National Infrastructure Planning  
Temple Quay House  
2 The Square  
Bristol, BS1 6PN

Our Ref: EN010106

### **Application by Sunnica Ltd for an Order Granting Development Consent for the Sunnica Energy Farm**

#### **Advice following issue of decision to accept the application for examination**

**Sheet 21 of 24**

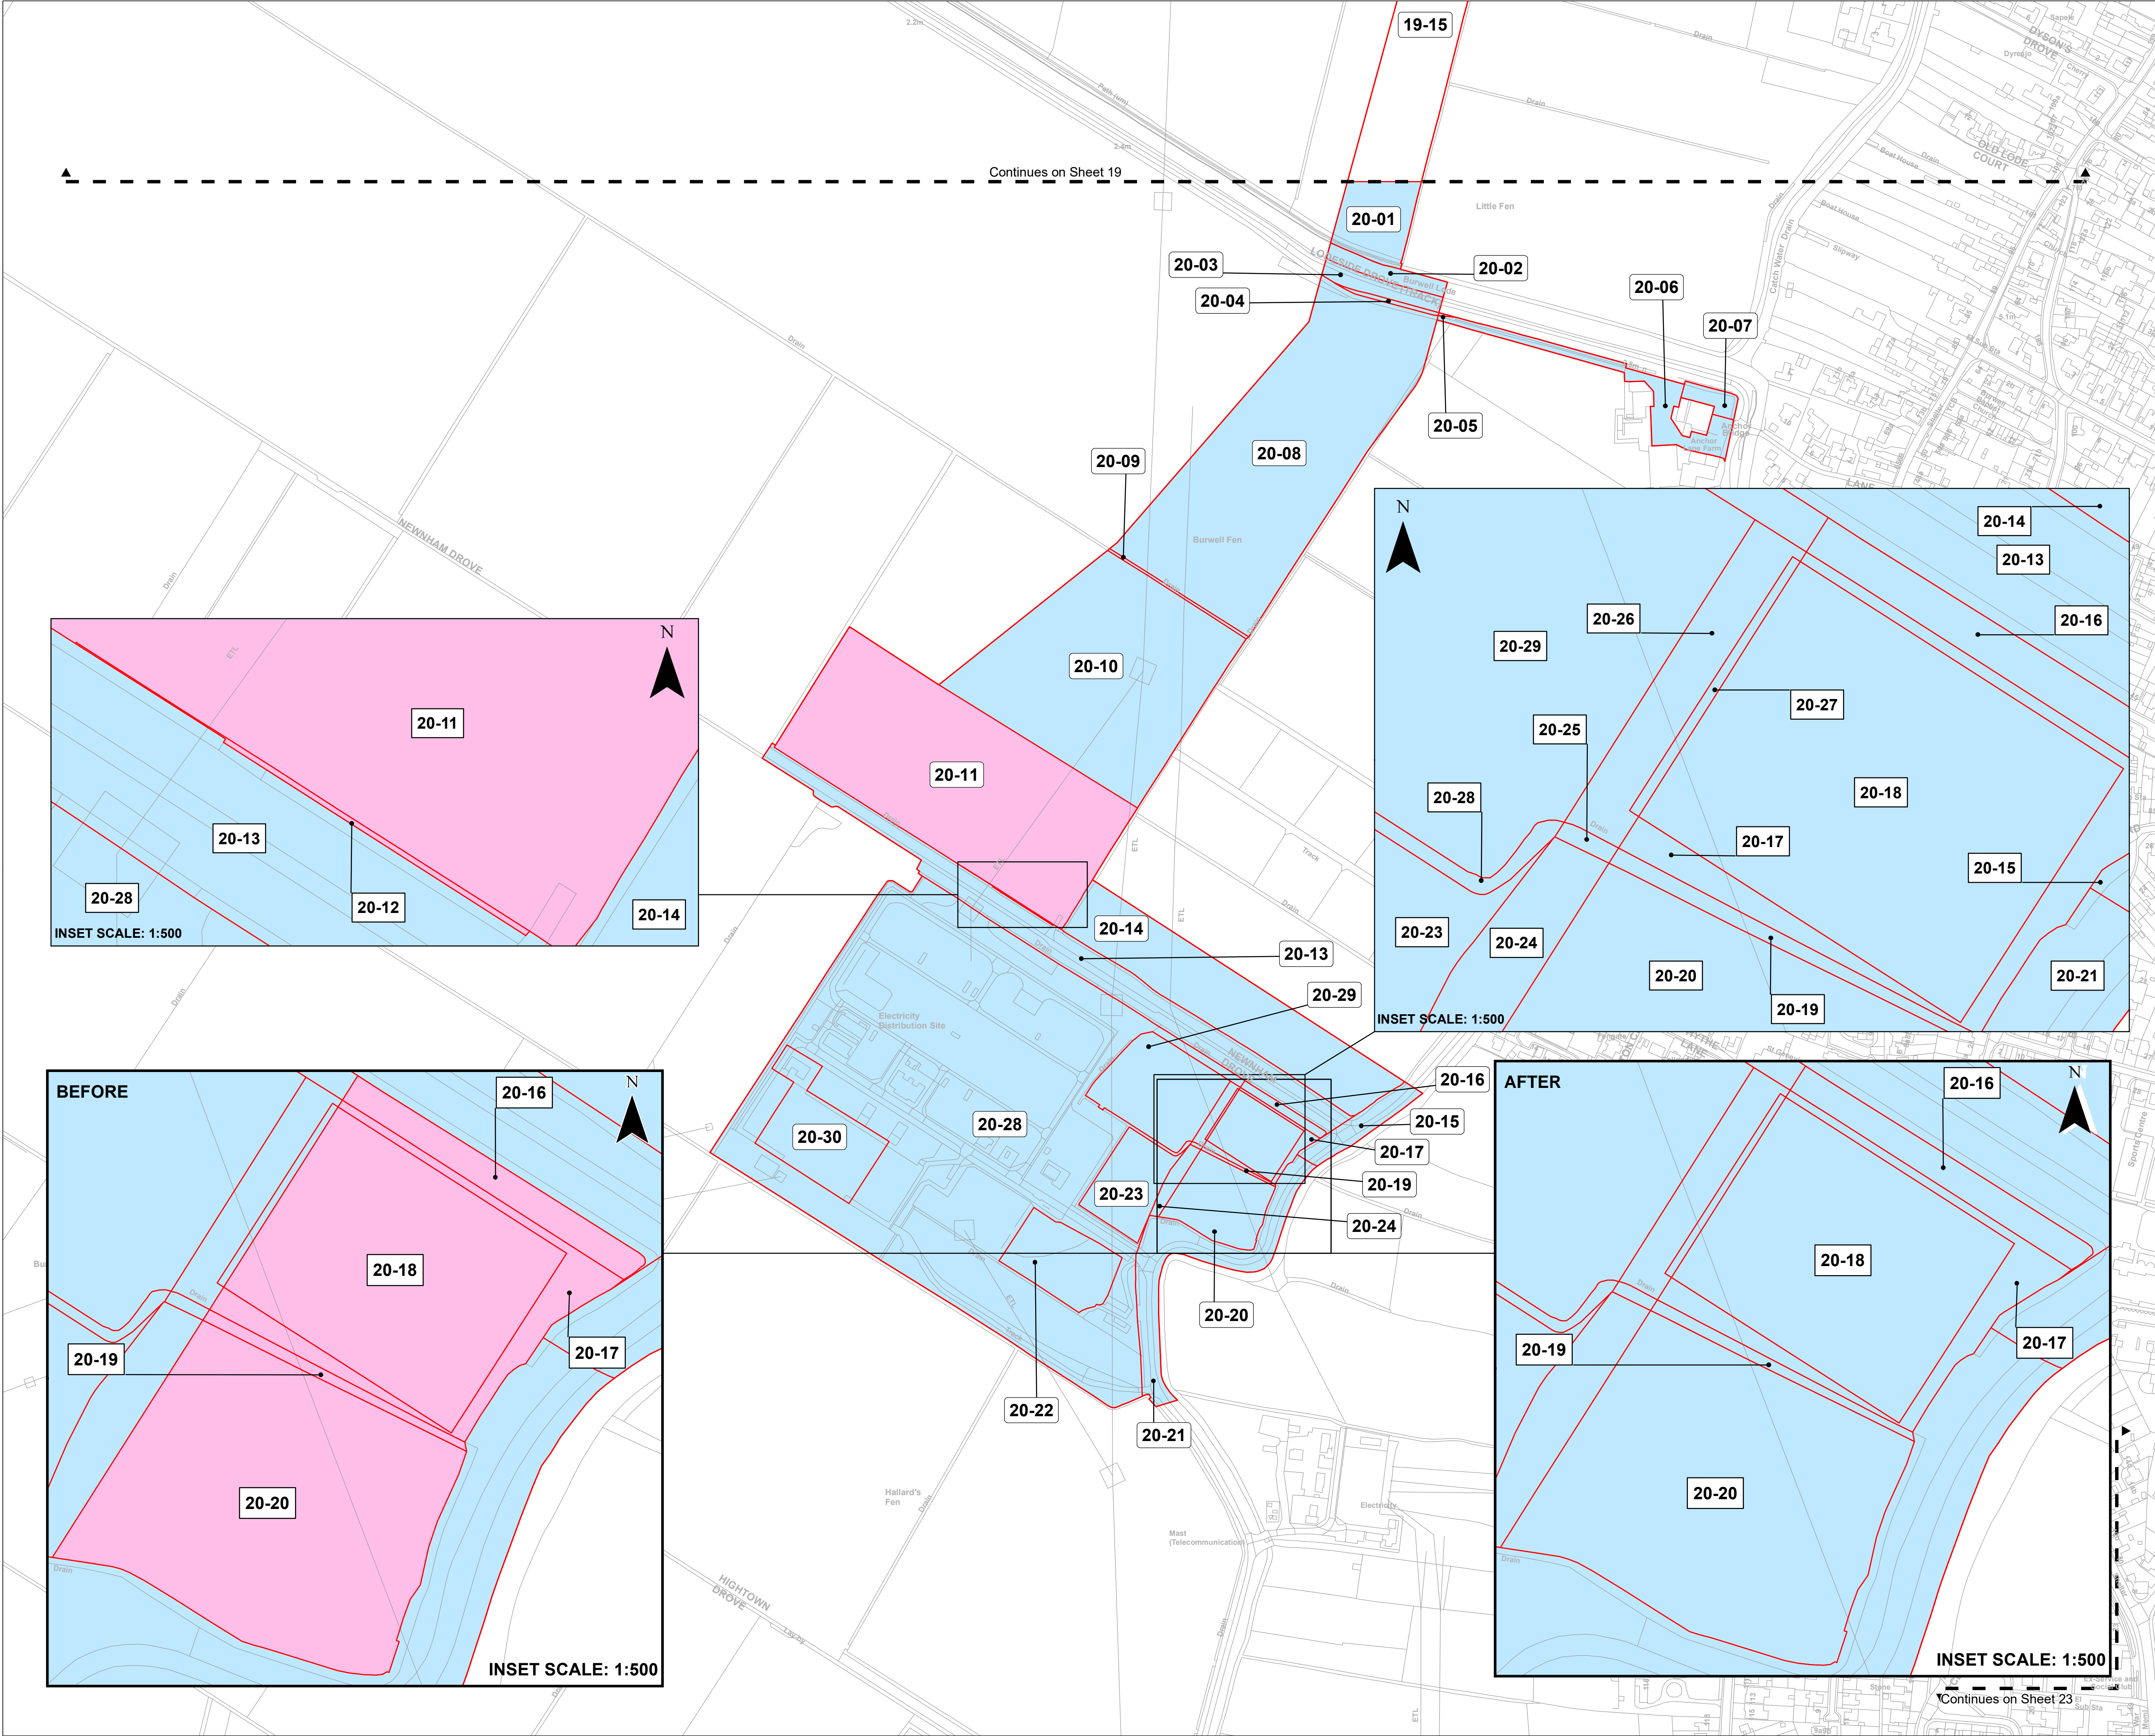
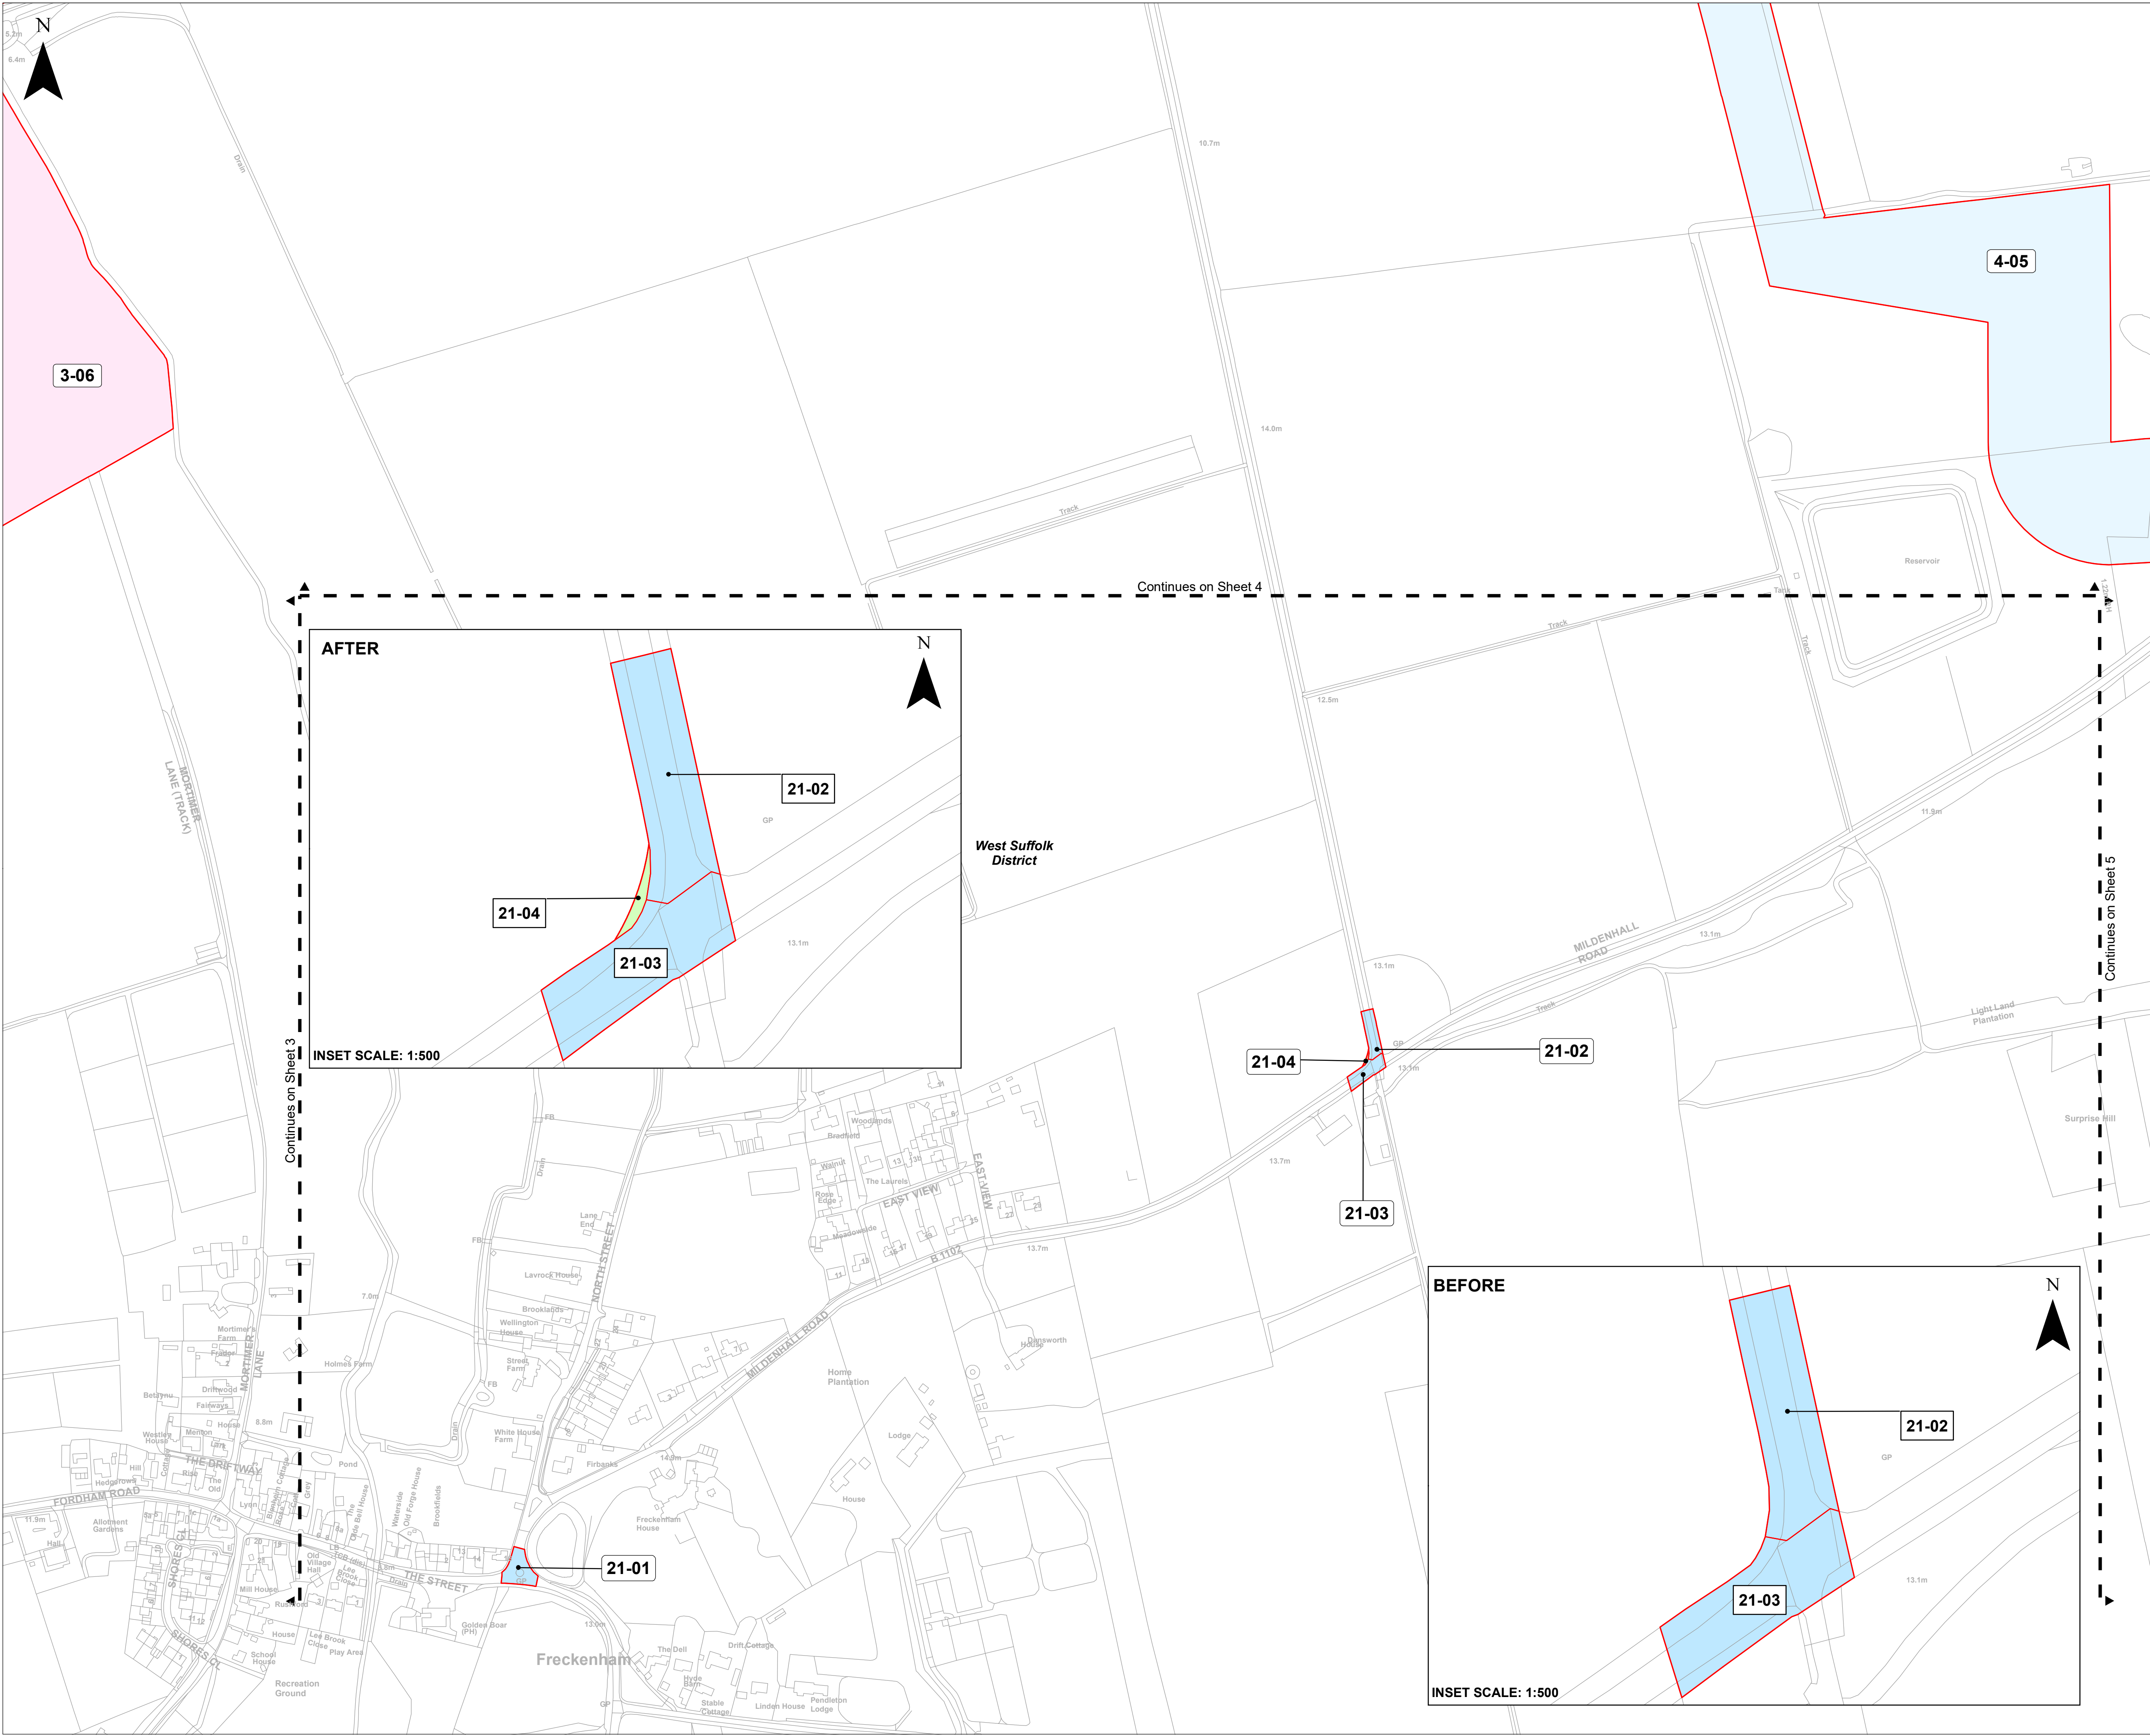
The Planning Inspectorate identified some discrepancies whilst checking the plans submitted with the application documents. Examples of errors are provided in Box 30 of the section 55 checklist. The Applicant is advised to conduct a thorough review of all the application plans and submit updated corrected versions as necessary.
